MEMORANDUM

SUBJECT: SF-19-009– Retreat at Timber Ridge Filing 1
Third Submittal

Engineering Division

RETREAT AT TIMBERRIDGE FILING NO. 1
CONSTRUCTION PLANS
STREET LIGHT POLE LOCATION PLAN

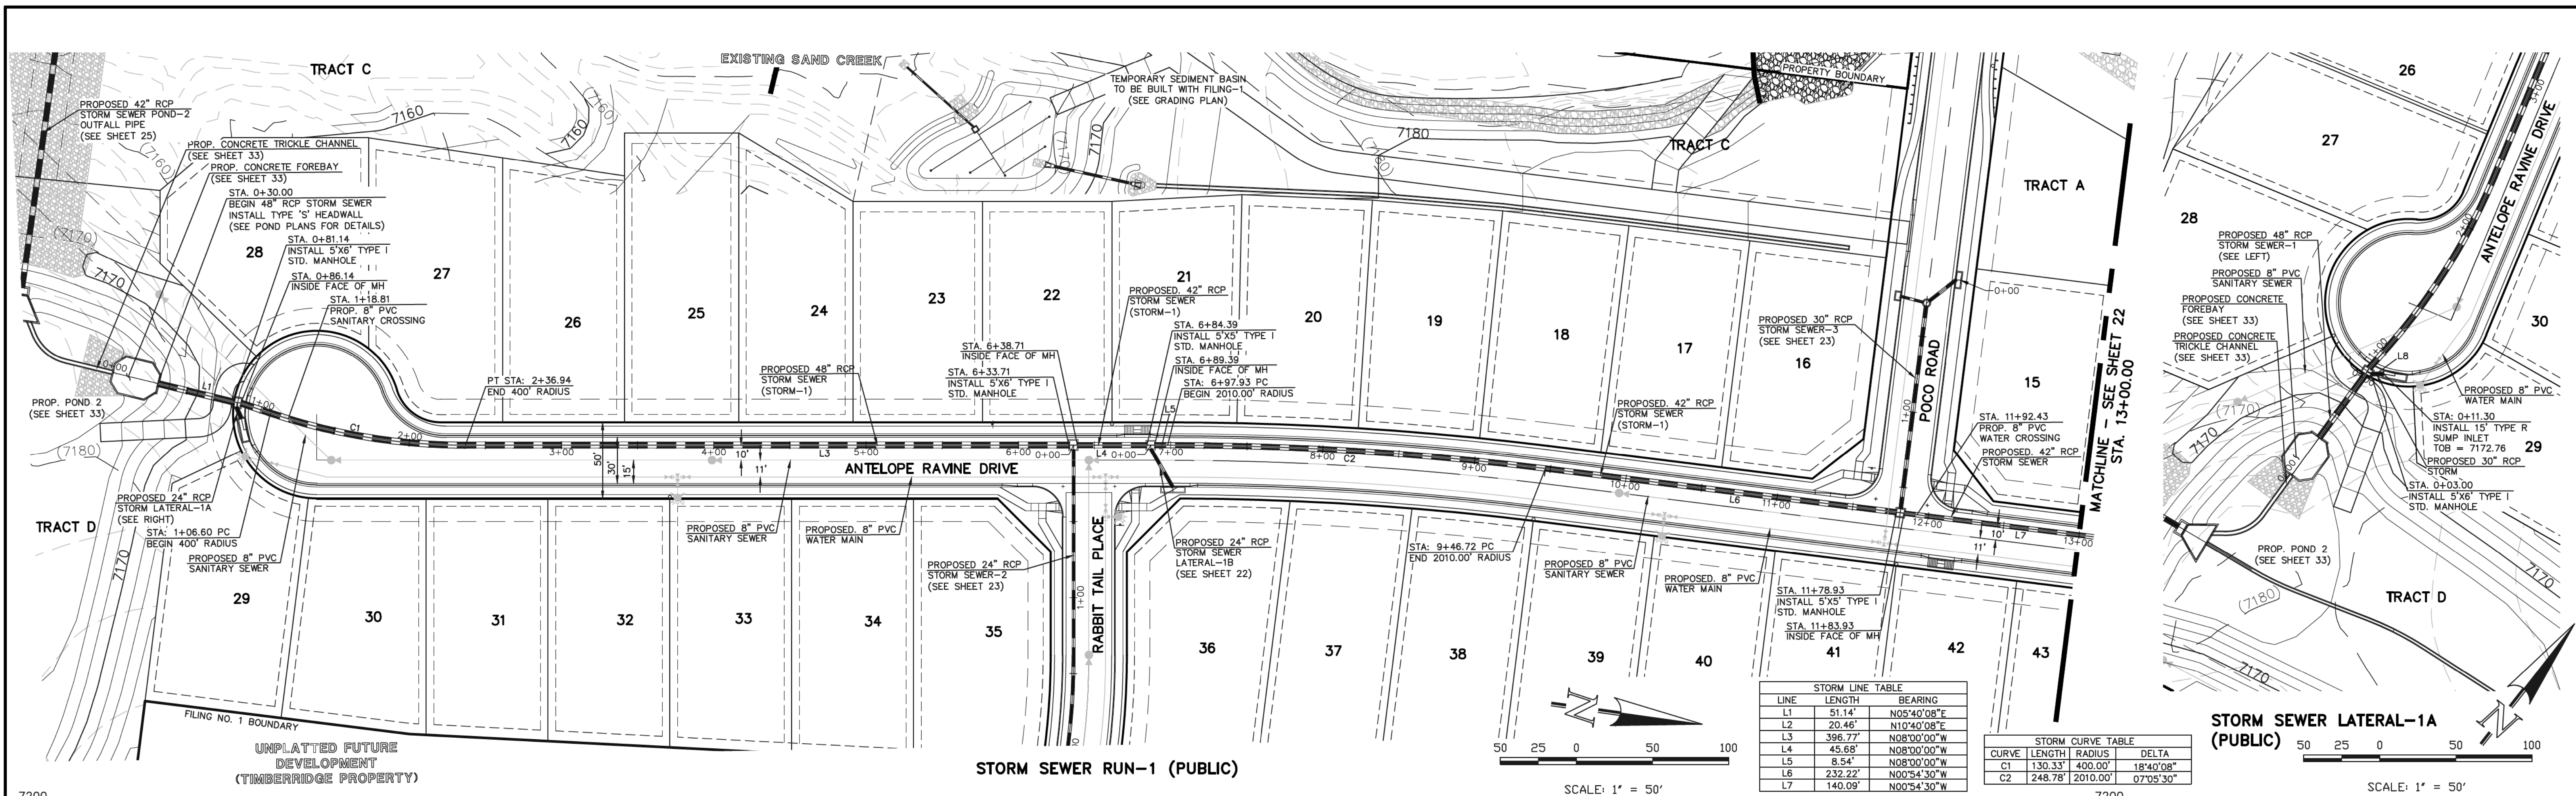
6. Address any proposed street lighting in the Letter of Intent. A license agreement will be required if streetlights are proposed within County rights-of-way. Resolved; a license agreement template can be provided upon request. Plan reviews and coordination between MVEA and County staff is required.
